# MAYBERRY COMMUNITIES

## SKETCH PLAN

EPC STORMWATER REVIEW COMMENTS  
IN ORANGE BOXES WITH BLACK TEXT

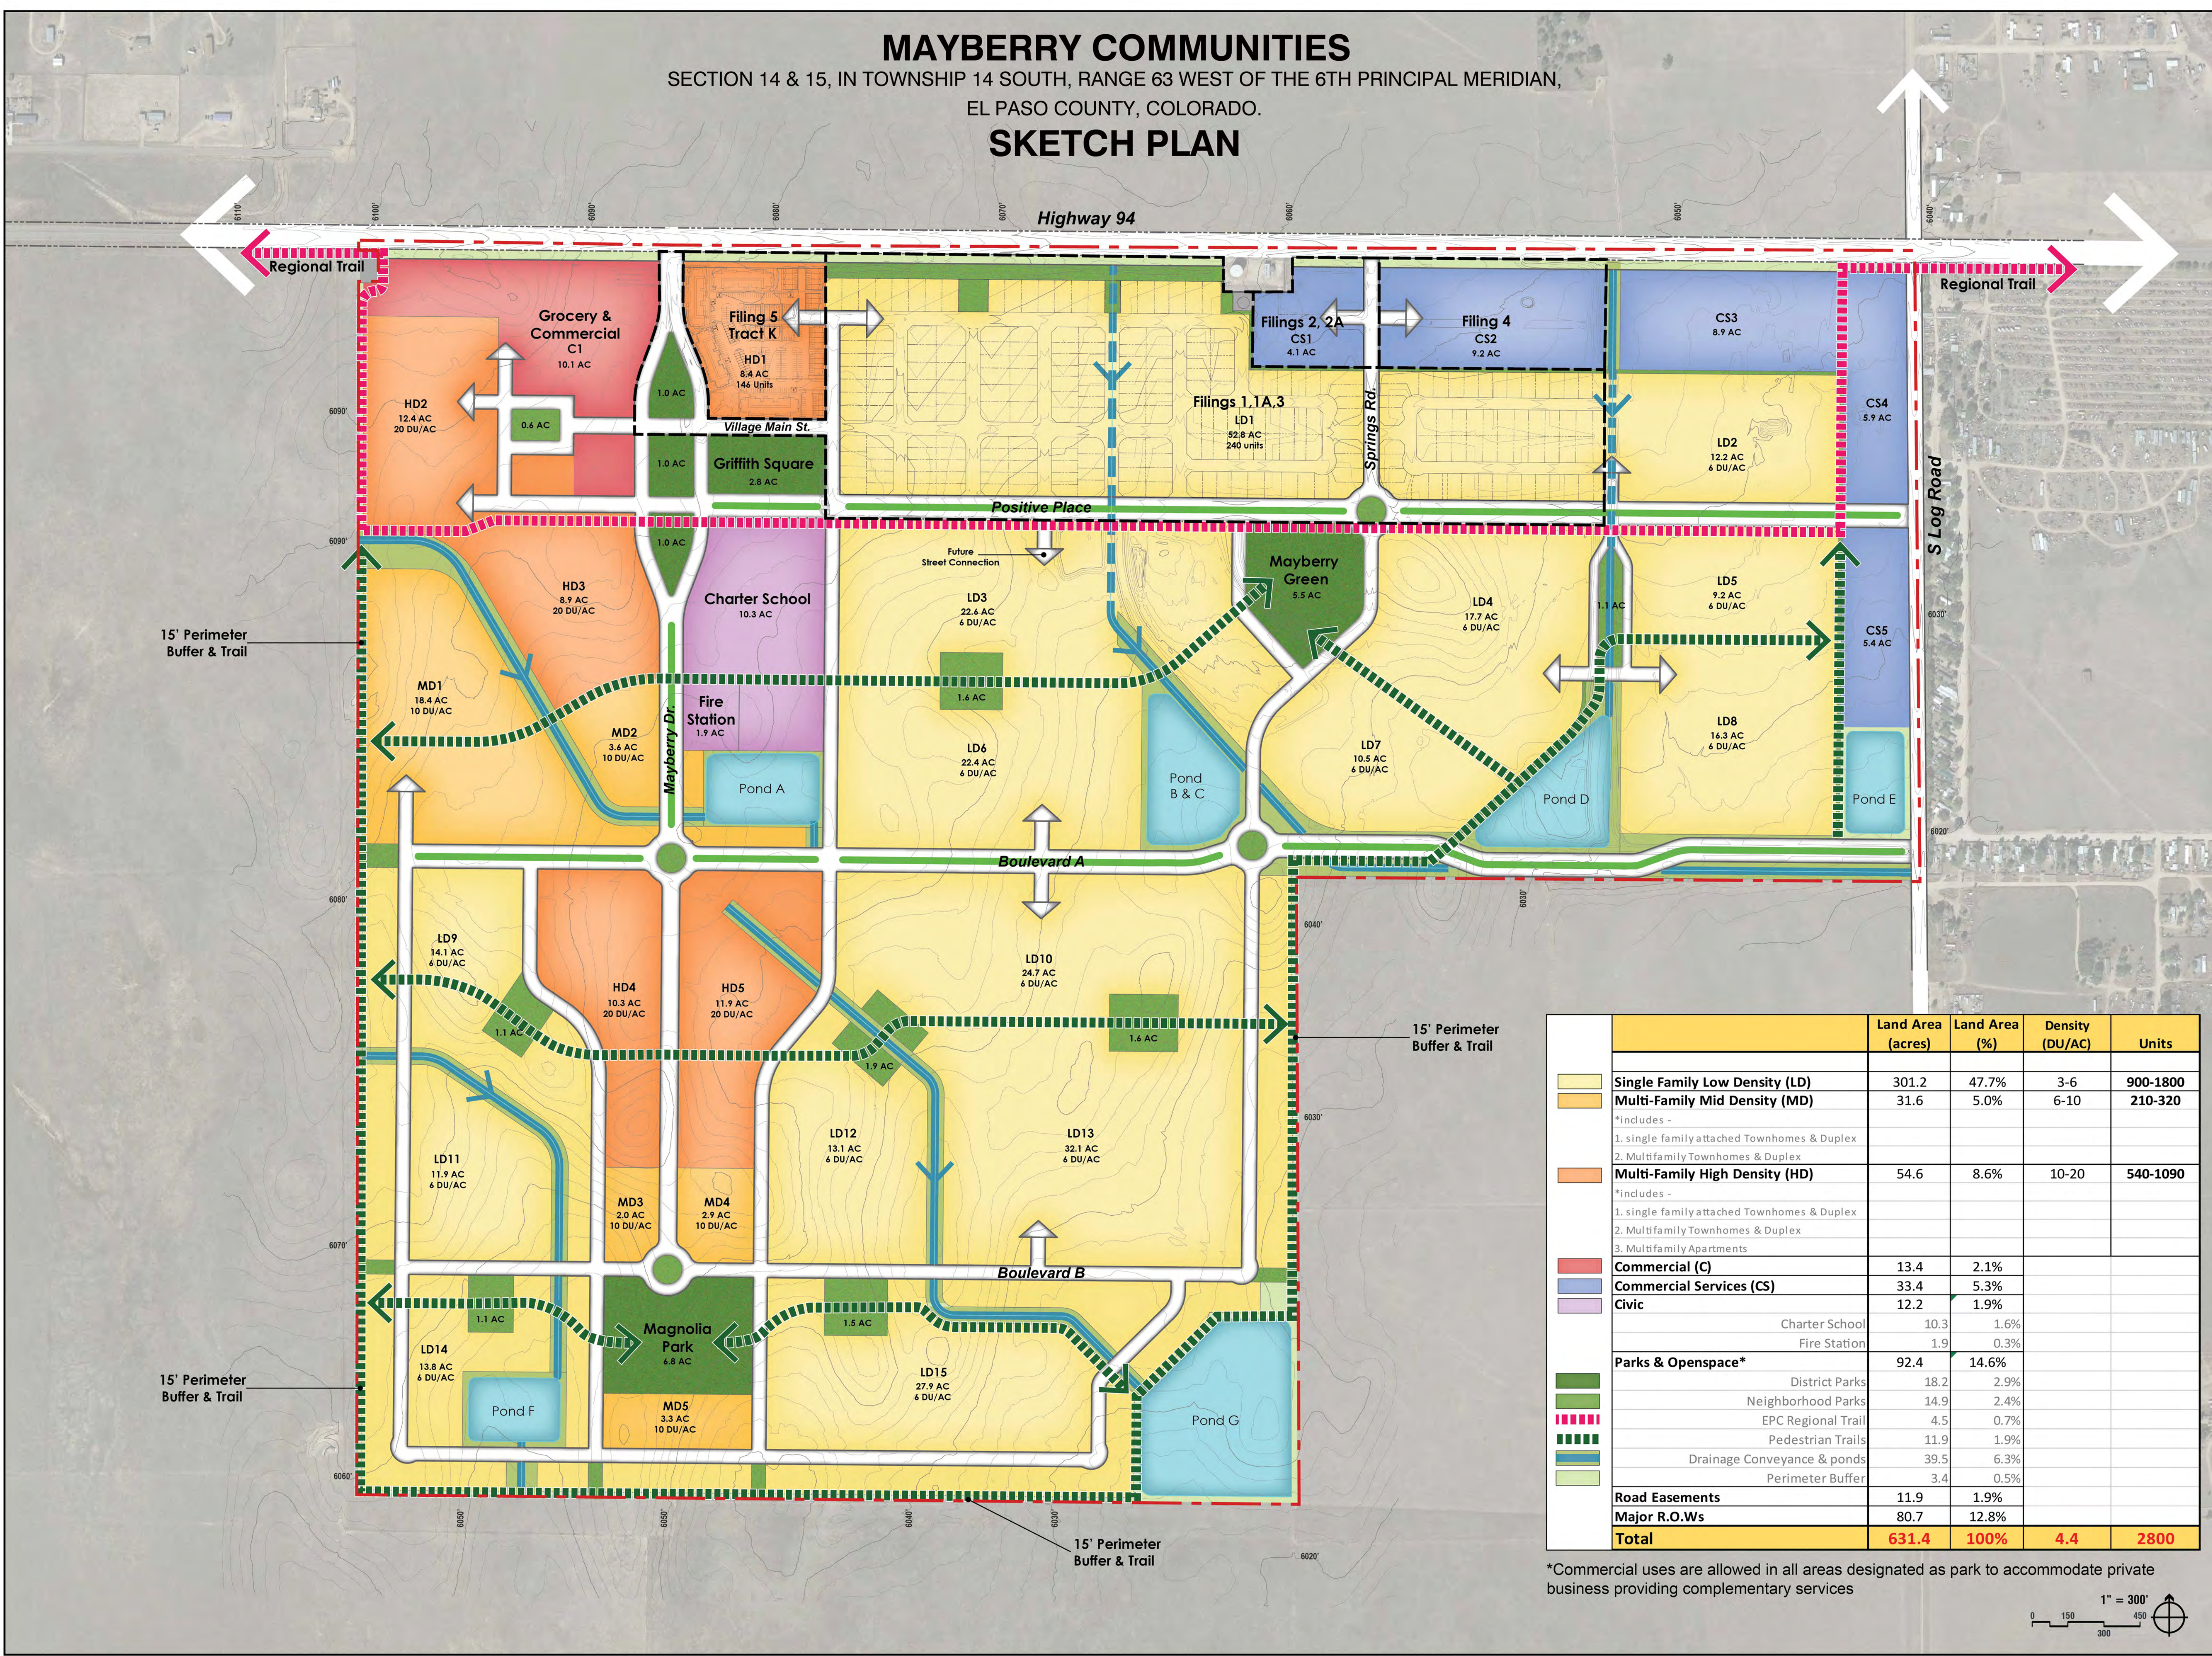
Although access is conceptual at this stage, please identify the proposed access for the commercial parcels on the north and east.

The site specific plan for this area shows trail connections to the existing Phase 1. Do these trails need to be called out on this plan as well?

Conform Parks is agreeable to relocating the HWY94 regional trail to this location.

provide classification of all the existing roadways and ROW width

Is this locked in as a charter school? Has the school district agreed that the land dedication would be for a charter school? Is this the only school dedication site required?

I would recommend incorporating some community commercial areas scattered throughout the central and southern areas of the development to continue to encourage active lifestyles, more walkability, etc. This is in no way a requirement, but may be a good addition to the community to improve quality of life for the potential residents.

provide classification and ROW width of the proposed major roadways (Collector and above)

It might be beneficial to just stick to maximums, because this will lock you into the minimums as well and would warrant a sketch plan amendment if you needed to adjust the minimums as well.

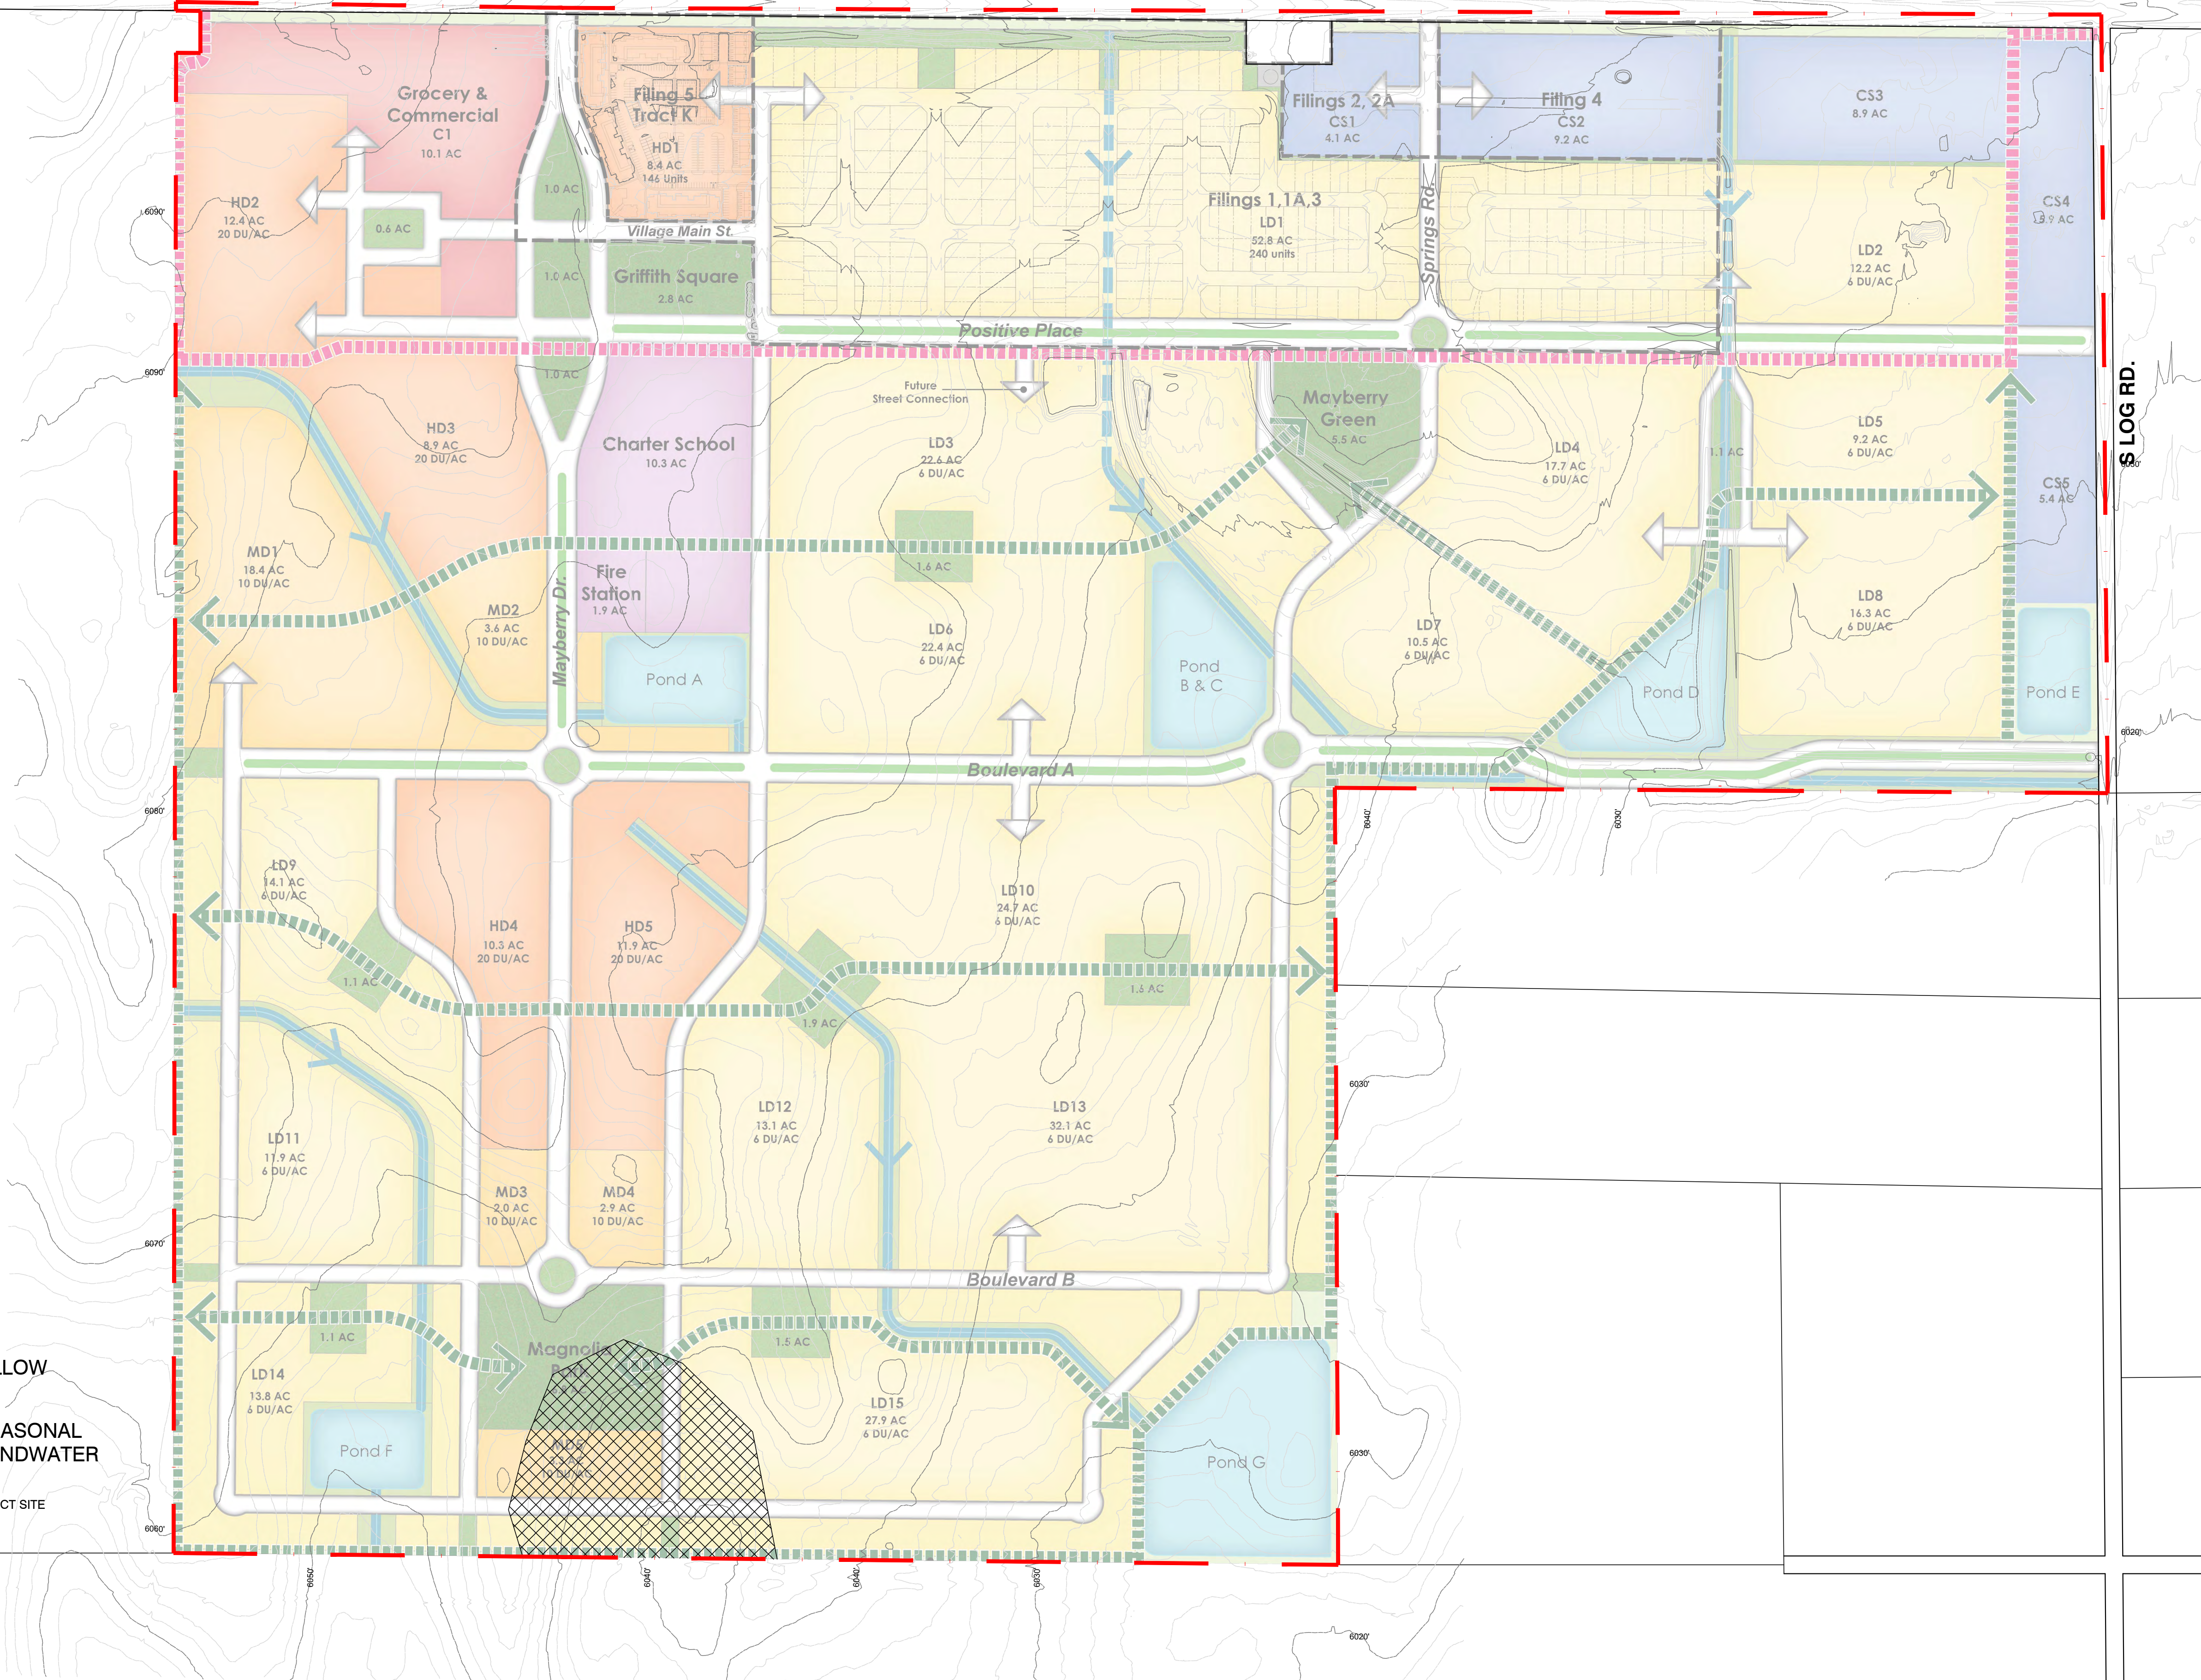
It is going to be difficult to develop in this area - I would recommend reallocating this land for something else, or if mitigation can be done to allow development. This area will need to be studied more intensively when development is proposed
